CITY OF PORTLAND

December 22, 2000

RE: 32-34 Prospect Street 124-E-004 - R-5 Zone

FOUNDATION PLAN
 AVRAM HAENS
 28' X 50' RANCH
 32-34 PROSPECT ST. PORTLAND

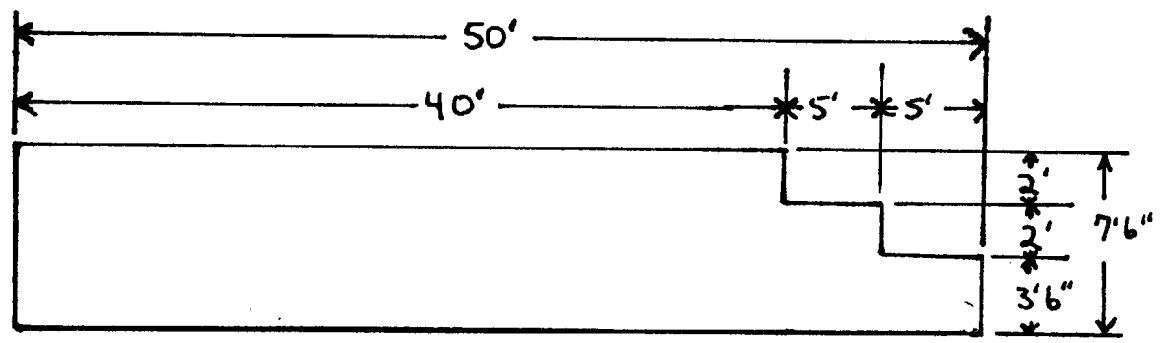
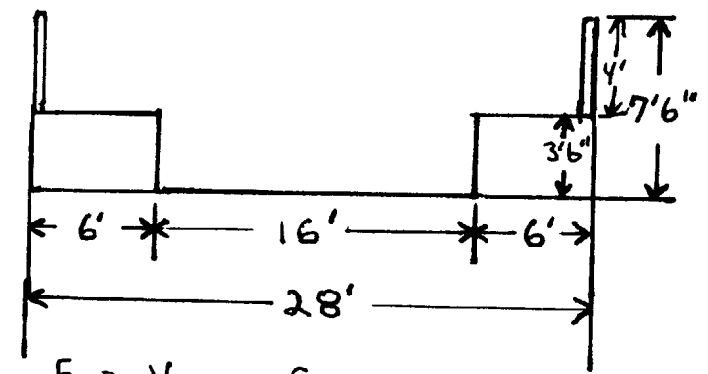
I have also noted that your contractor states that he will be constructing a masonry chimney. Neither your structural plans nor your plot plan show the location of this chimney. Is this an internal or exterior chimney? If it is exterior, such a chimney would need to be shown on your plot plan with all the appropriate setbacks denoted. If it is interior, that should be shown on your construction plans. The height above the roof line should be shown on your plans.

PLOT PLAN
 AVRAM HAINS
 28' X 50' RANCH
 32-34 PROSPECT ST. PORTLAND
 AMENDED PLAN
 DATED: DEC. 28, 2000

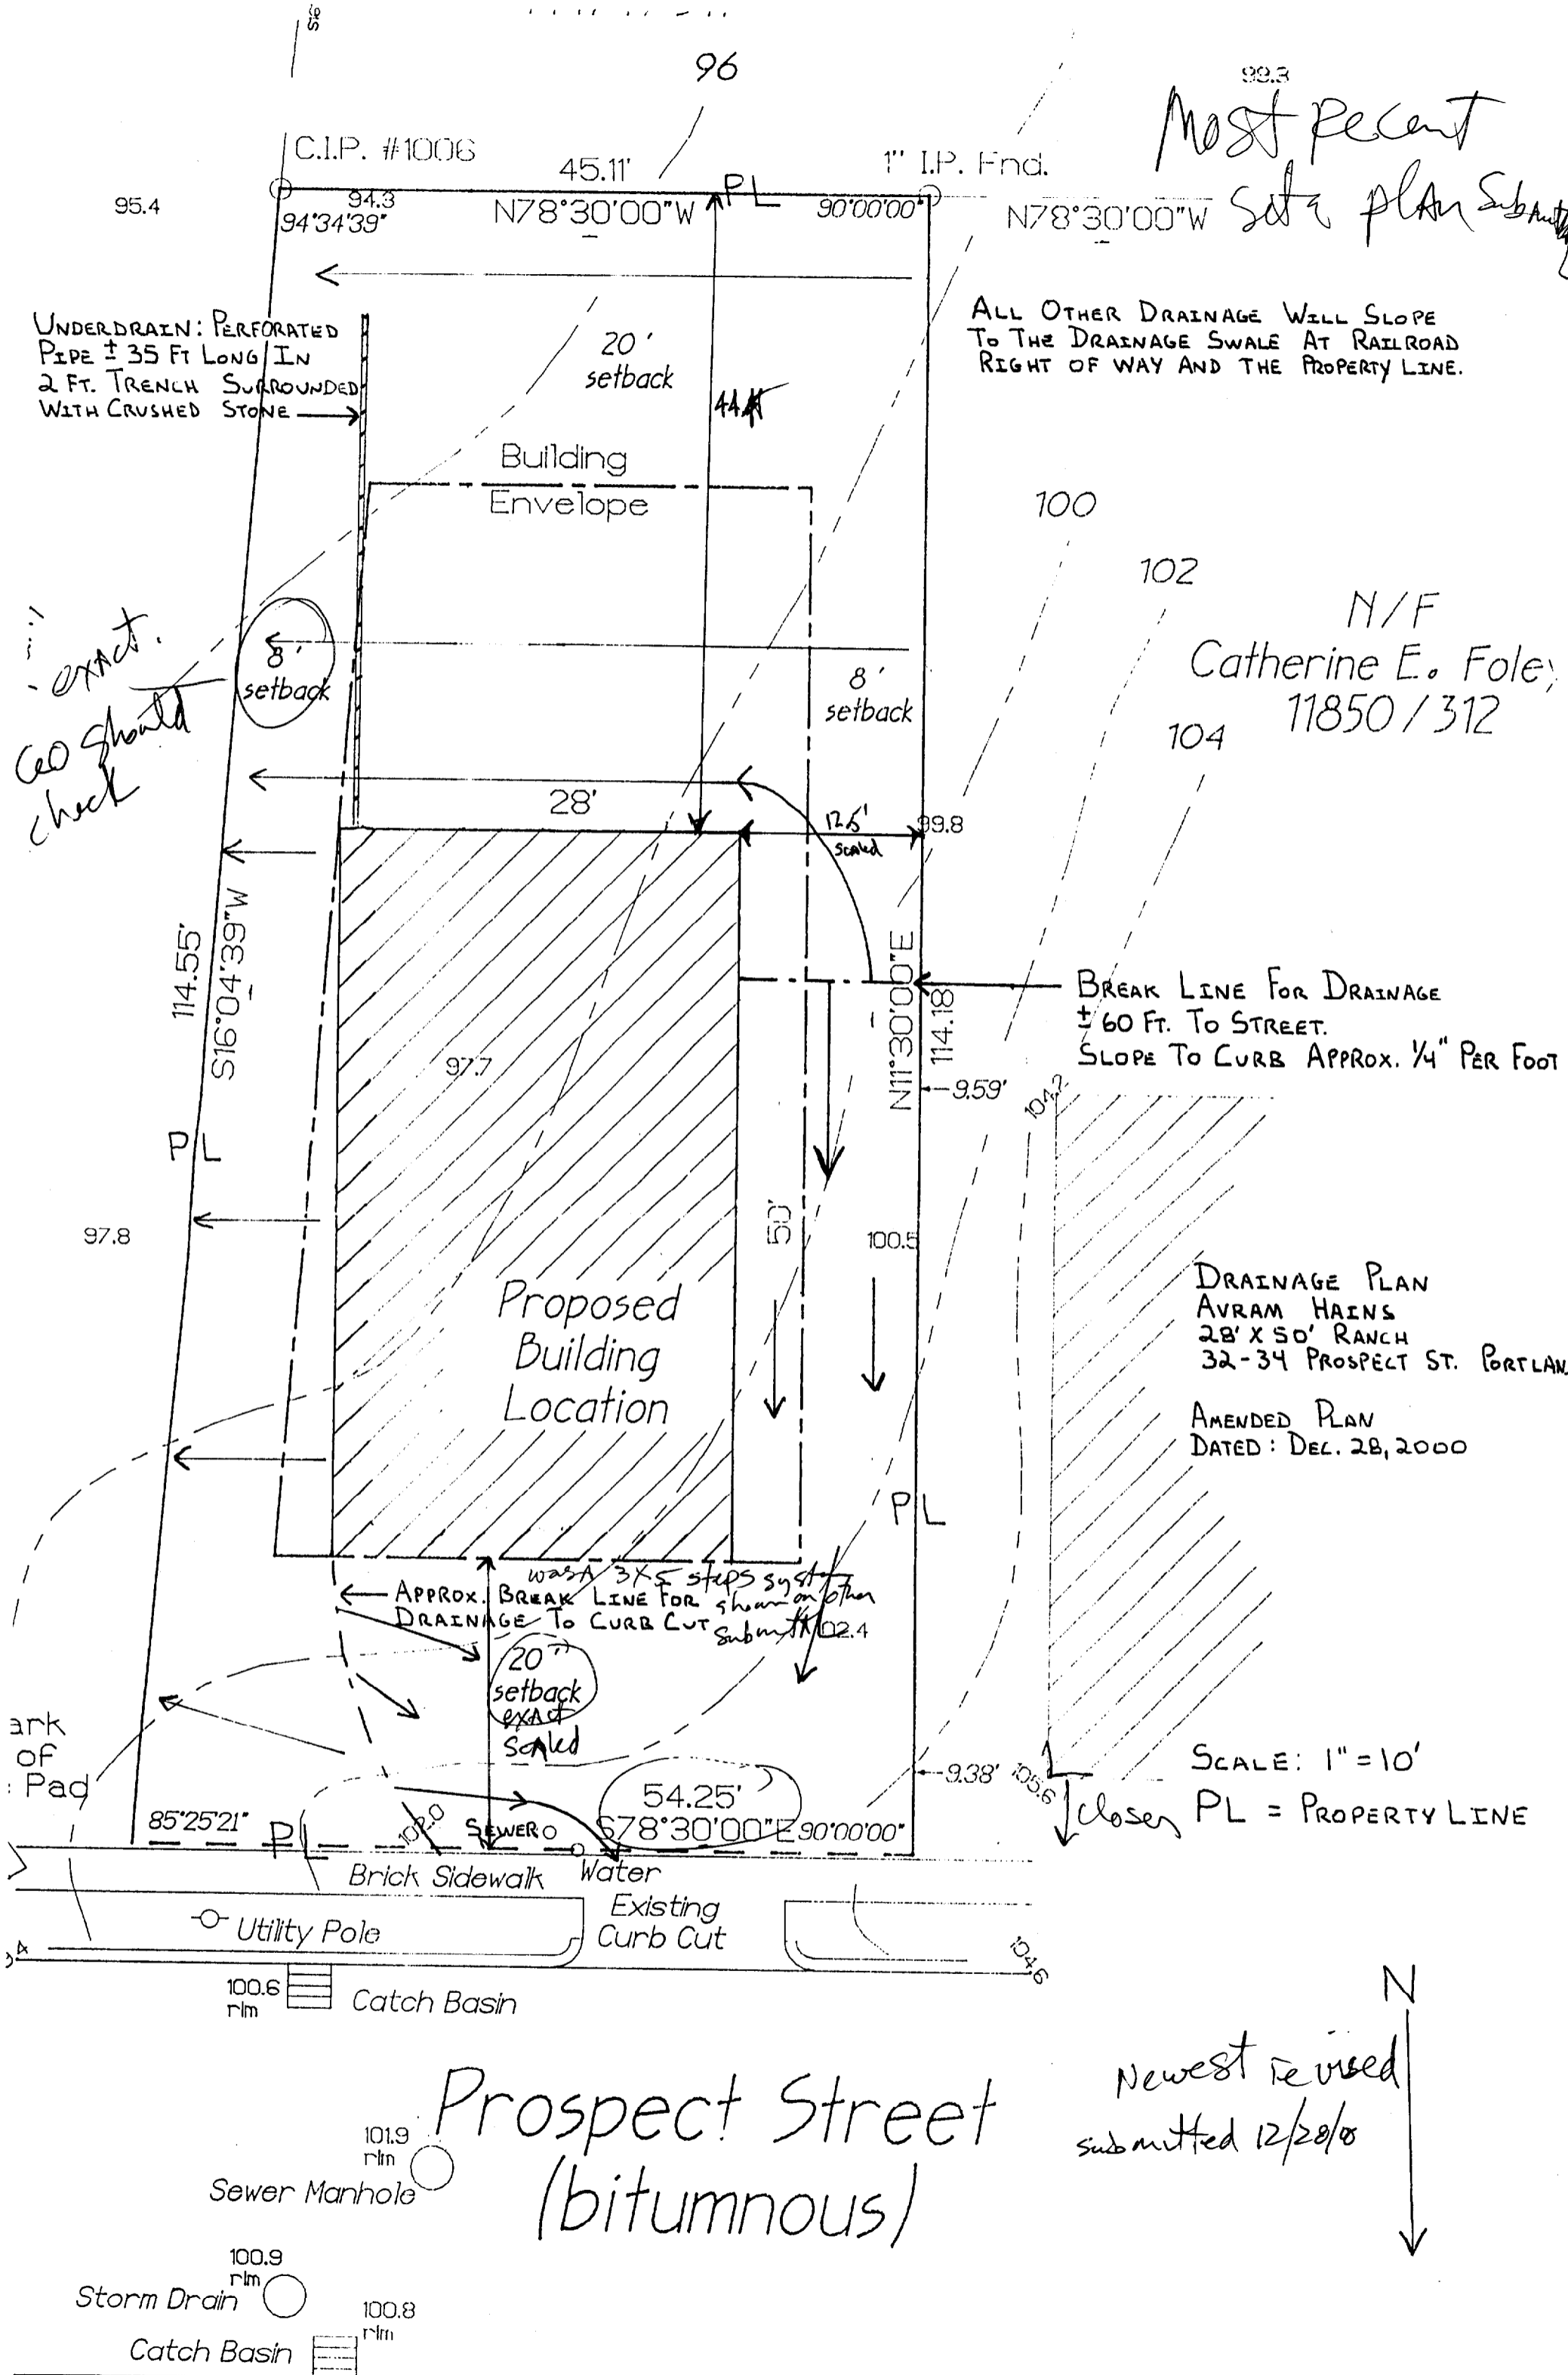
I am in receipt of your building application to construct a new single family home at 32-34 Prospect Street. This property is located within the R-5 residential zone which requires a minimum lot size of 6,000 sq. ft. You are showing that this lot is only 5,672 sq. ft. Before I can allow you to build, you would need to document that this lot can meet the requirements of a lot of record as defined in section 14-433 of the zoning ordinance. You would need to show me that this lot was held under separate and distinct ownership from any adjacent lots since June 5, 1957.
